PORTLAND MAINE

October 4, 2010

Re: 85 Gray Street – 057 D034 – R-6 – rebuild deck & stairs – permit #10-1218

PLOT PLAN

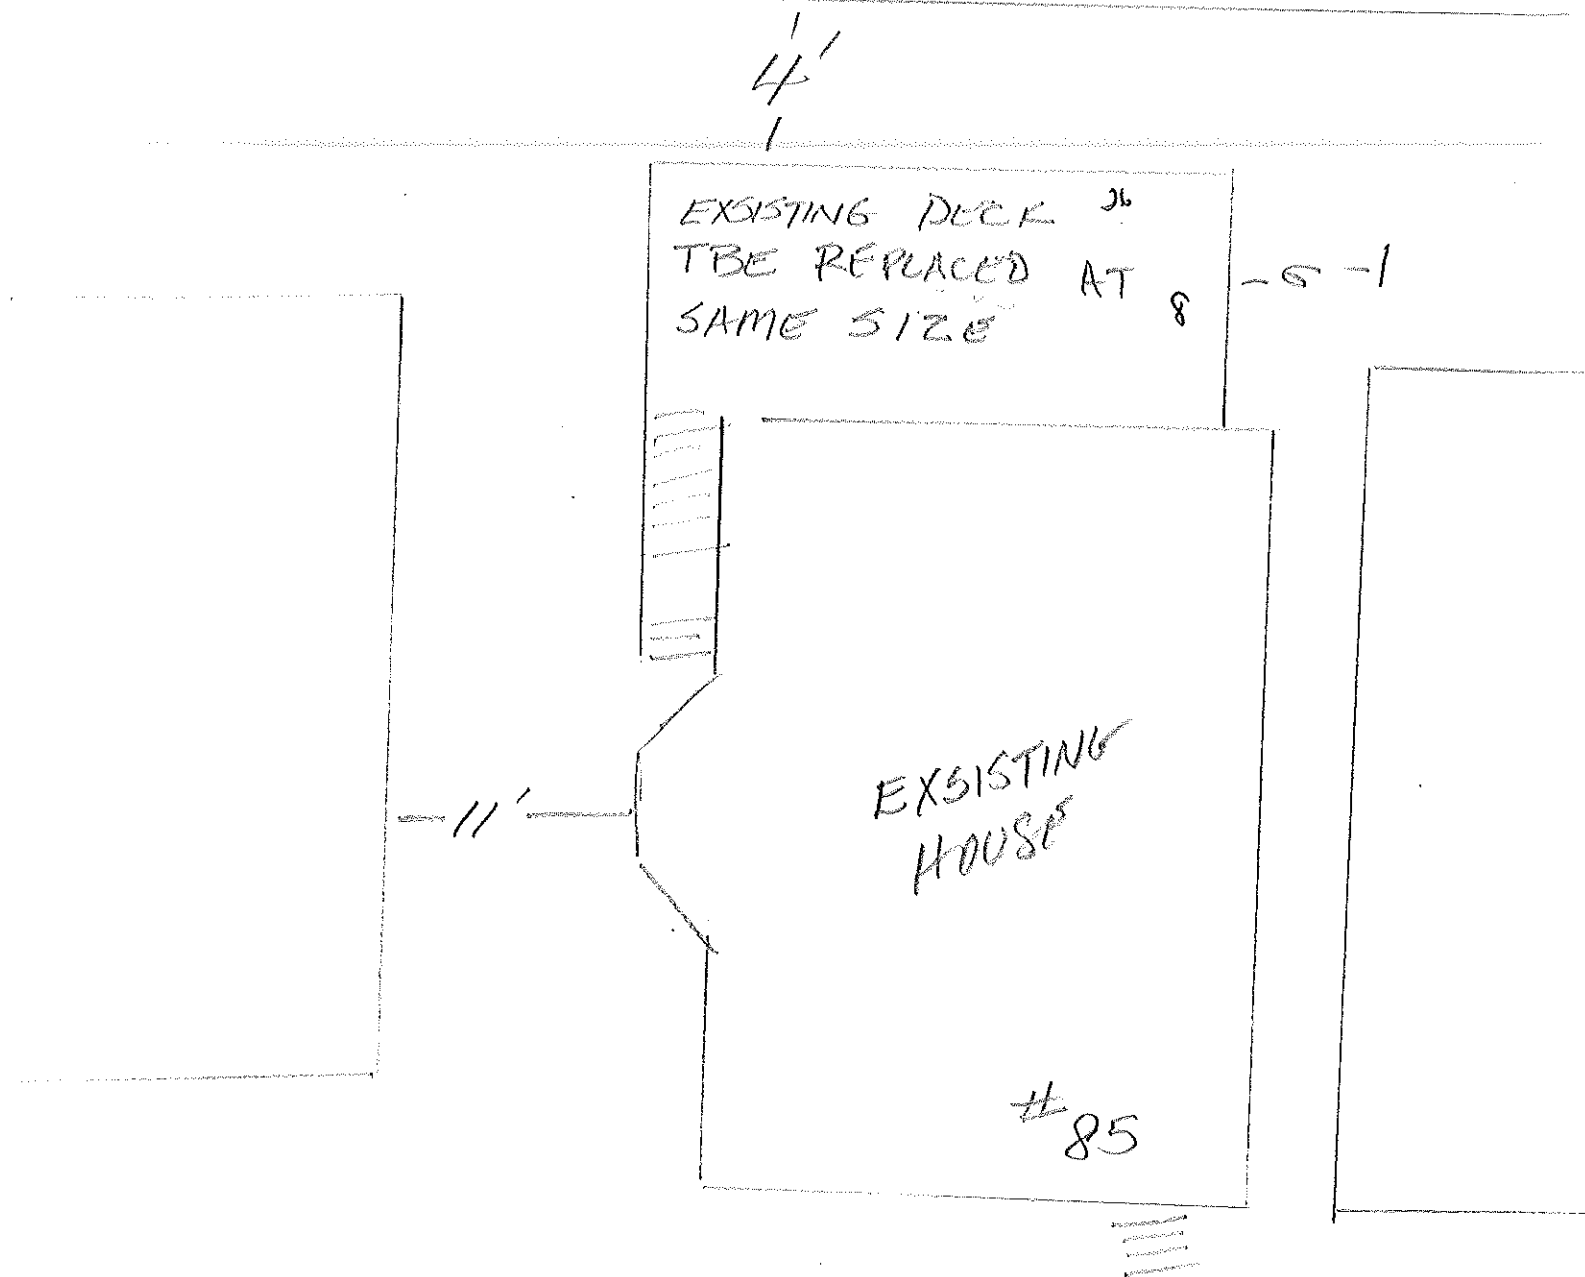
The deck and stairs at 85 Gray Street are nonconforming because they do not meet the required setbacks and lot coverage. 85 Gray Street is located in the R-6 residential zone. The required rear setback is twenty feet [section 14-139(d)(2)]. The plot plan gives the rear yard setback to the deck as four feet. The required side yard setback is ten feet [section 14-139(d)(3)(a)]. The plot plan gives the distances to the abutting buildings as eleven feet on the left and six feet on the right. The proposed stairs and deck need to be ten feet from the property lines. Finally, the maximum allowable lot coverage for the R-6 zone is fifty percent [section 14-139(e)]. The lot is 1969 square feet. The existing building, bay windows, and front entry cover 1060 square feet. The proposed deck and stairs cover 250 square feet of the lot. The total square footage would be 1310 square feet which would cover 66.5% of the lot.

Part of our review process when we receive an application to replace a structure that is nonconforming is to see if the structure was originally permitted. I have researched our files and I cannot find a permit to build an eight foot by twenty-three foot deck and a three foot by fourteen foot set of stairs. If the deck and stairs were not permitted, the deck is not legal, and it cannot be rebuilt. The property must be brought into compliance. You have thirty days from the date of the letter to do this. Our office will work with you to achieve compliance, but since there is no permit for the original deck, it needs to be removed.
